Response to WSCC Strategic Planning Consultation Comments dated 30 November 2012

Proposed housing development at

Roundstone Lane, Angmering
Arun Planning Application A/82/12

12 December 2012

NOTES:

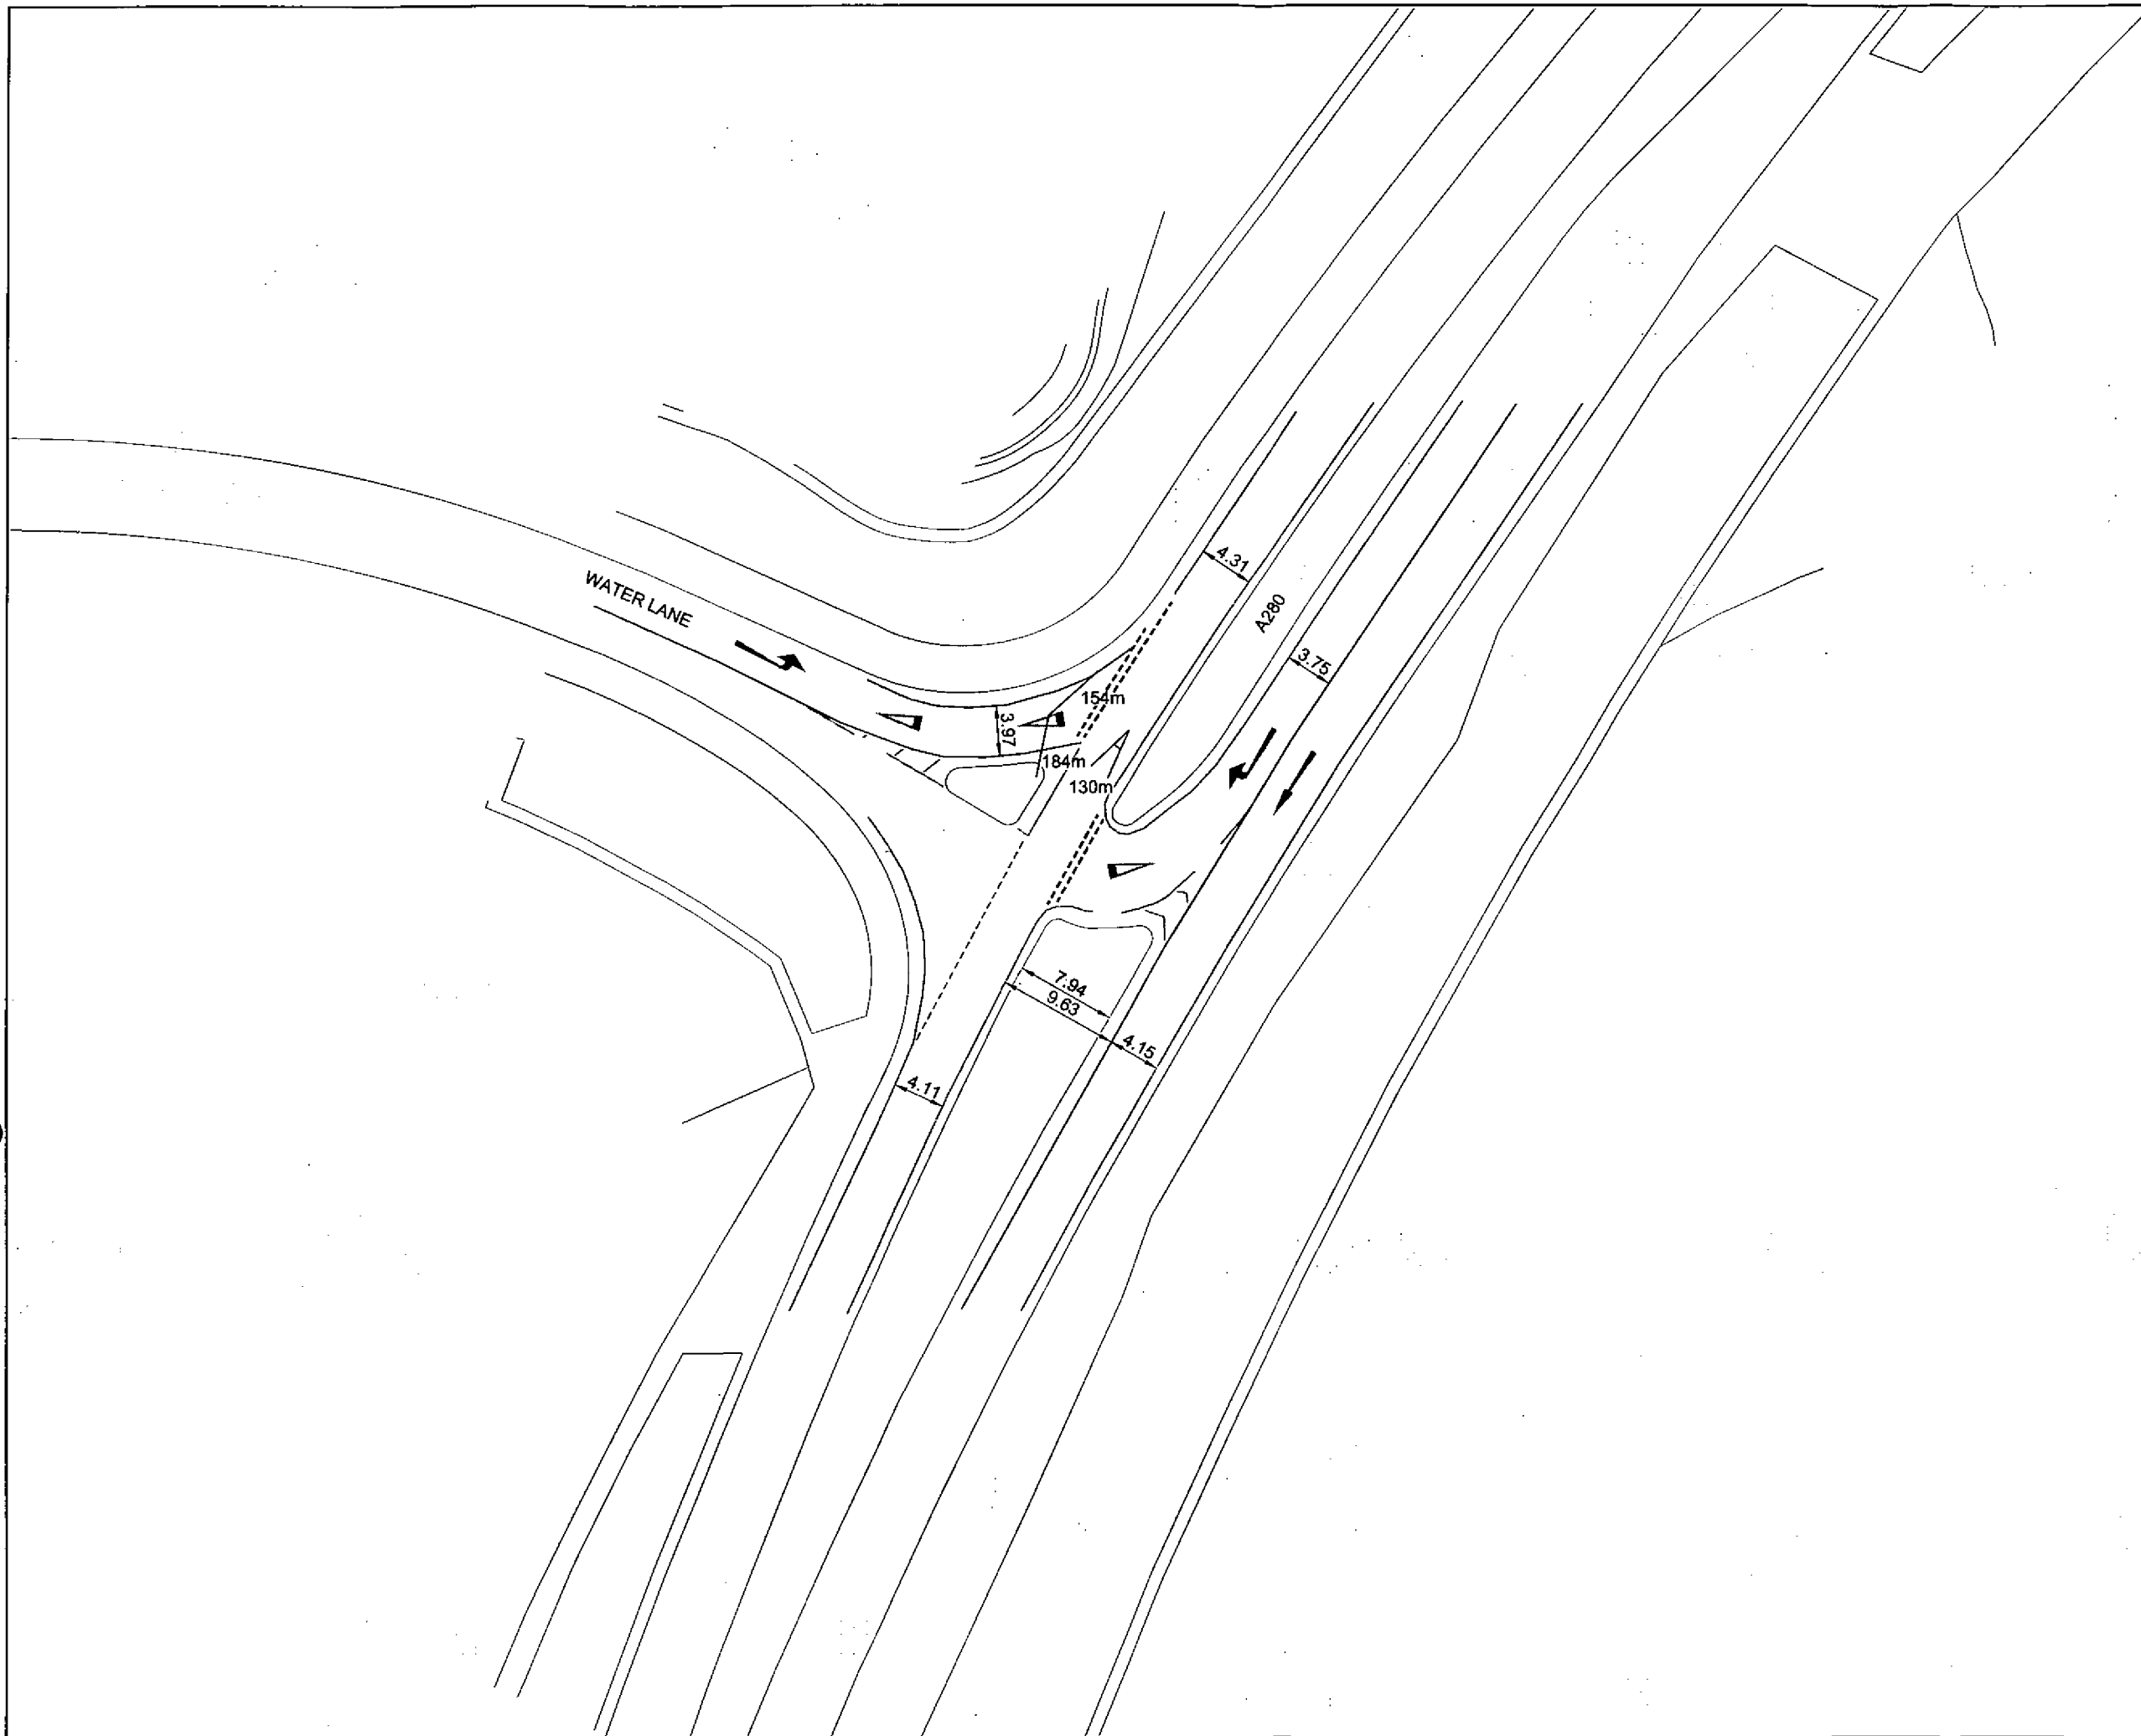
All input geometry has been rechecked and minor alteration made to the models where necessary. Drawings 22067/112 – 118 highlighting the input geometry used to analyse the Roundabouts and T junctions are attached in Appendix 1.

Drawing 22067/104C Proposed Raised Junction

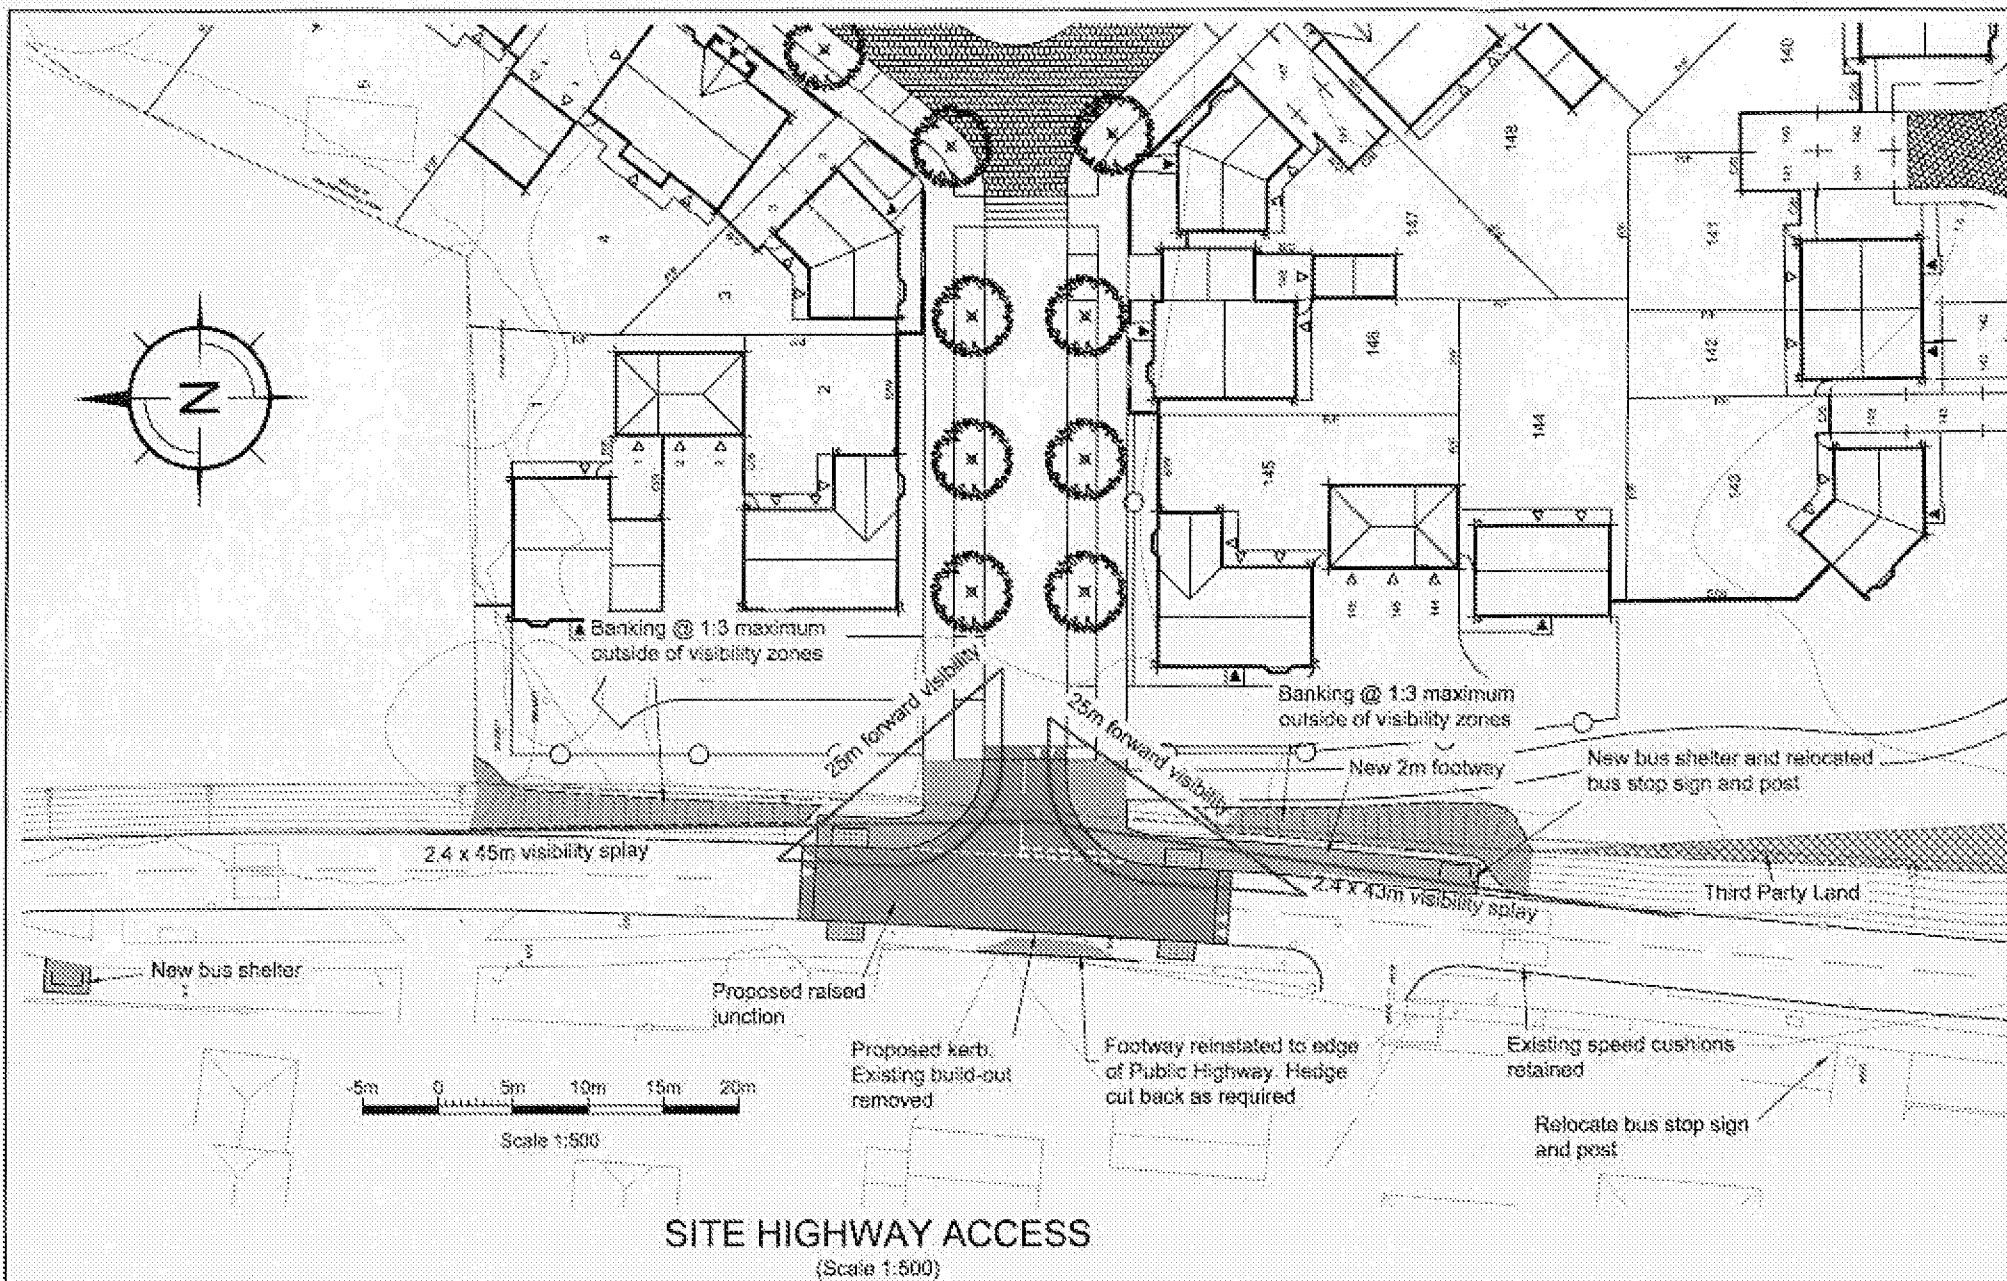
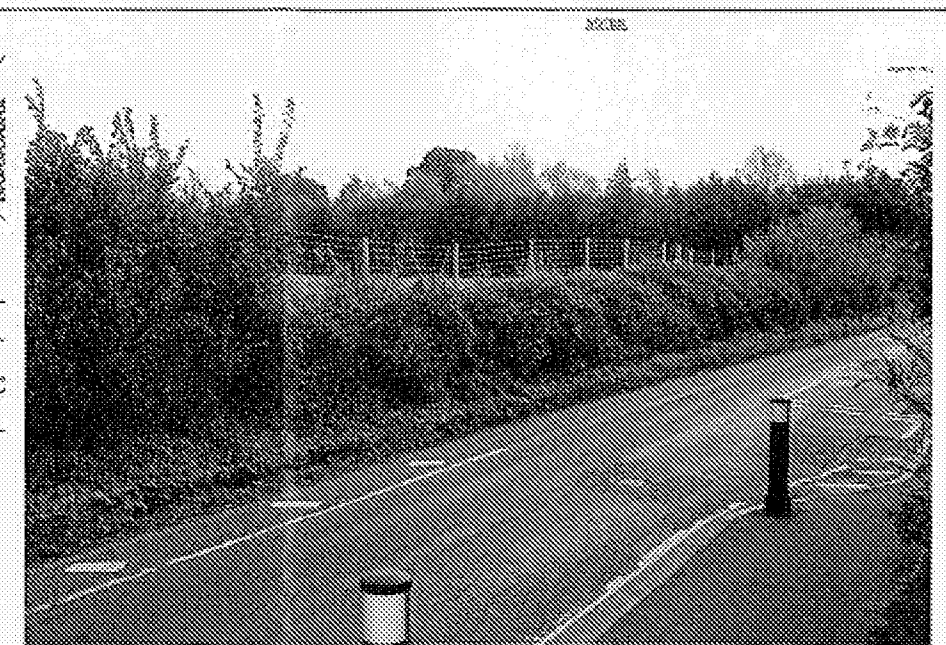
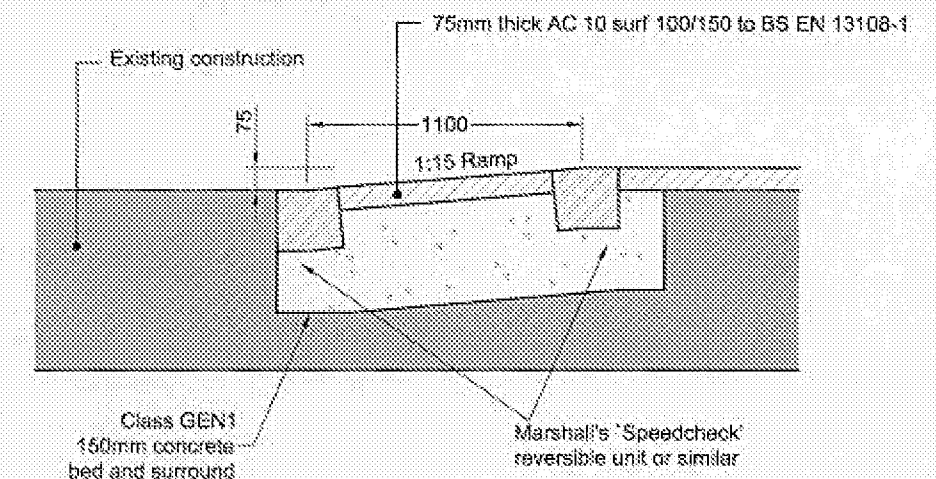
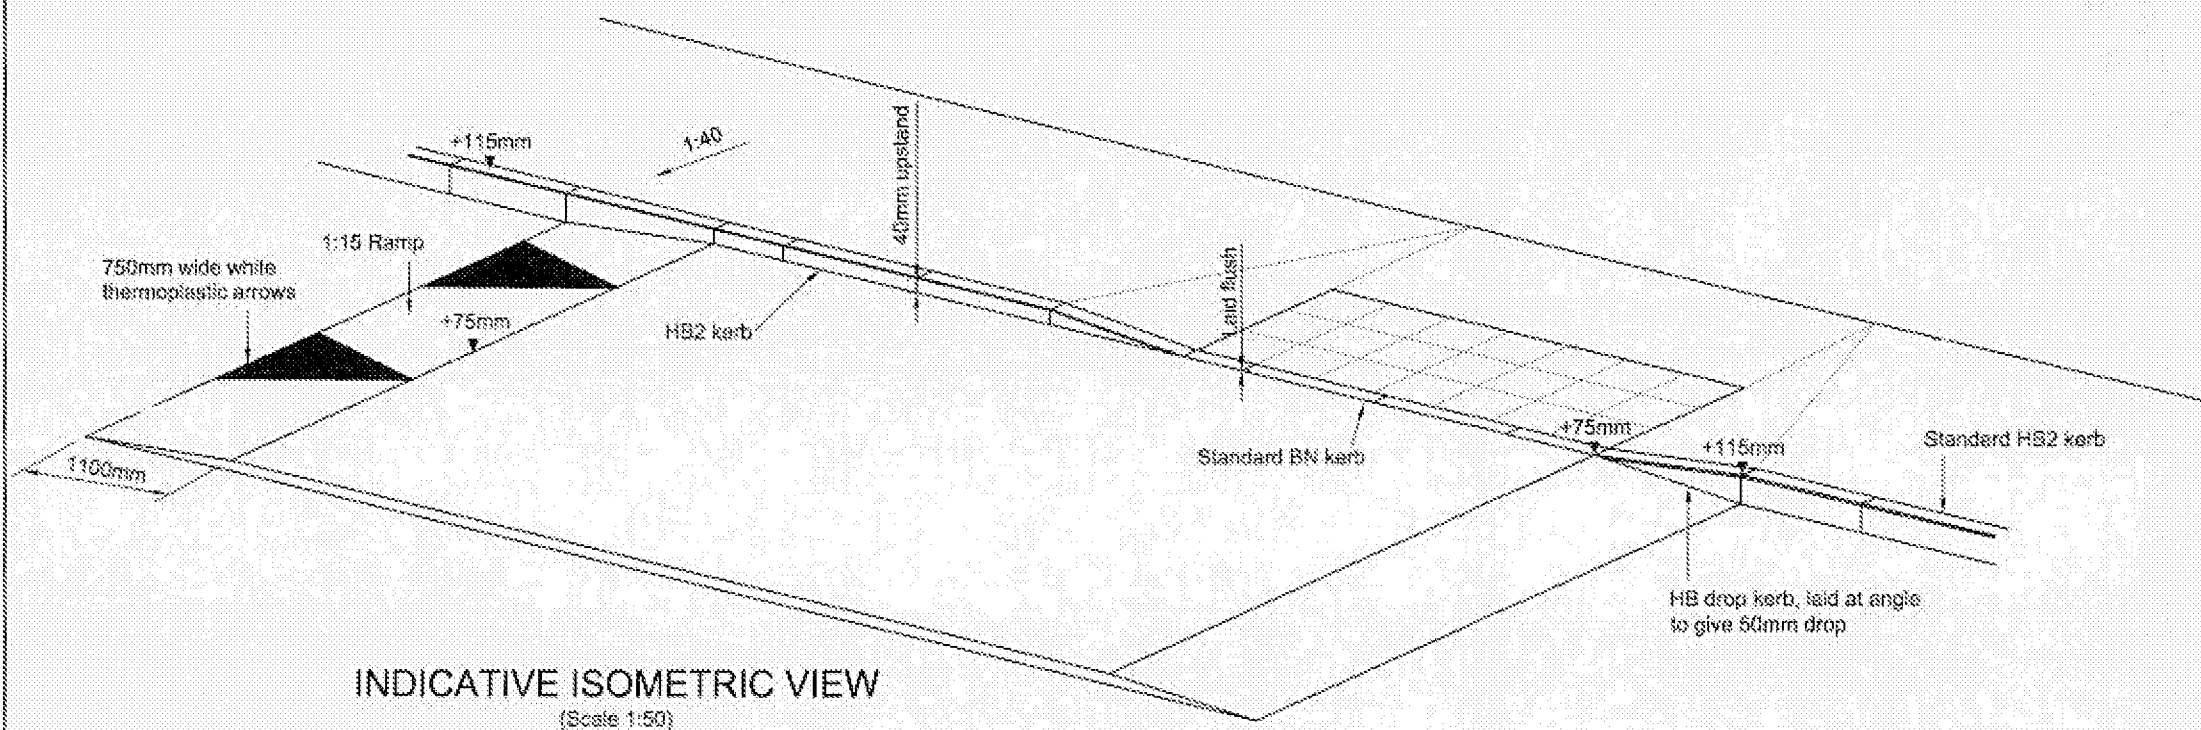
'1. First private access points within the estate layout adjacent to the junction with Roundstone Lane should be moved away from the junction area. As shown, they are too close and there is the risk that collisions may take place.'

'2. Further detail of the bellmouth of the junction with Roundstone Lane should be shown. Width of access road (first 50 or so metres up to the 'divide in the internal layout) to be shown and full detail of footway. As shown at present, the detail is incomplete.'

'3. Sight line at junction of access road with Roundstone Lane to be shown following advice in MfS and based on recorded wet weather 85% tile speeds.'

'4. Flint walls adjacent to the back edge of footways to be maximum height of 0.6m to maintain pedestrian intervisibility. The other alternative would be for the walls to be lowered to 0.6m for 2.4 x 2m intervisibility splays either side of vehicular access points or the walls tapered back on an angle to provide the splays.'

The proposed access arrangement is shown on drawing 22067/104C attached in Appendix 3.

Drawing 22067/104C now indicates an extended footway along the site frontage where land ownership permits which provides for the southbound bus stop to be relocated onto the correct side of the street. Bus stops on both sides are shown to be equipped with shelters and seating.

The driveways in question are each side of the access road 7m and 10m respectively from the giveaway lines. The preliminary design for the entrance includes a speed reducing feature and 6m radii corners both of which would control vehicle speeds entering the site.

Forward visibility stopping sight distances corresponding to 20mph are shown and although this speed would be excessive around the entry radii it identifies the areas of land which should be kept clear of visual obstacle for the driveway entrances to be seen on approach.

The Road Safety Audit team finds no problem with this layout other than the sightlines should be kept clear of obstruction and the level difference should be considered in the detailed design.

These driveways each serve parking spaces for three dwellings and pedestrian access for two dwellings. In a slow speed situation within a residential street with adequate visibility the design organisation does not consider there is an undue risk of collision and the arrangement is in accordance with Manual for Streets (2007).

This is shown on the Preliminary Design drawing 22067/104C attached.

Sightlines of 2.4x43m and 2.4x45m are shown on drawing 22067/104C attached and will be kept clear of visual obstruction.

There will not be a need for retaining walls and any entrance feature will be located behind both the junction and forward visibility splays.

Bus stop improvements are shown on drawing 22067/104C. The Stagecoach number 9 route buses are not equipped with GPS and the route does not use real time technology for any other bus stop signs.
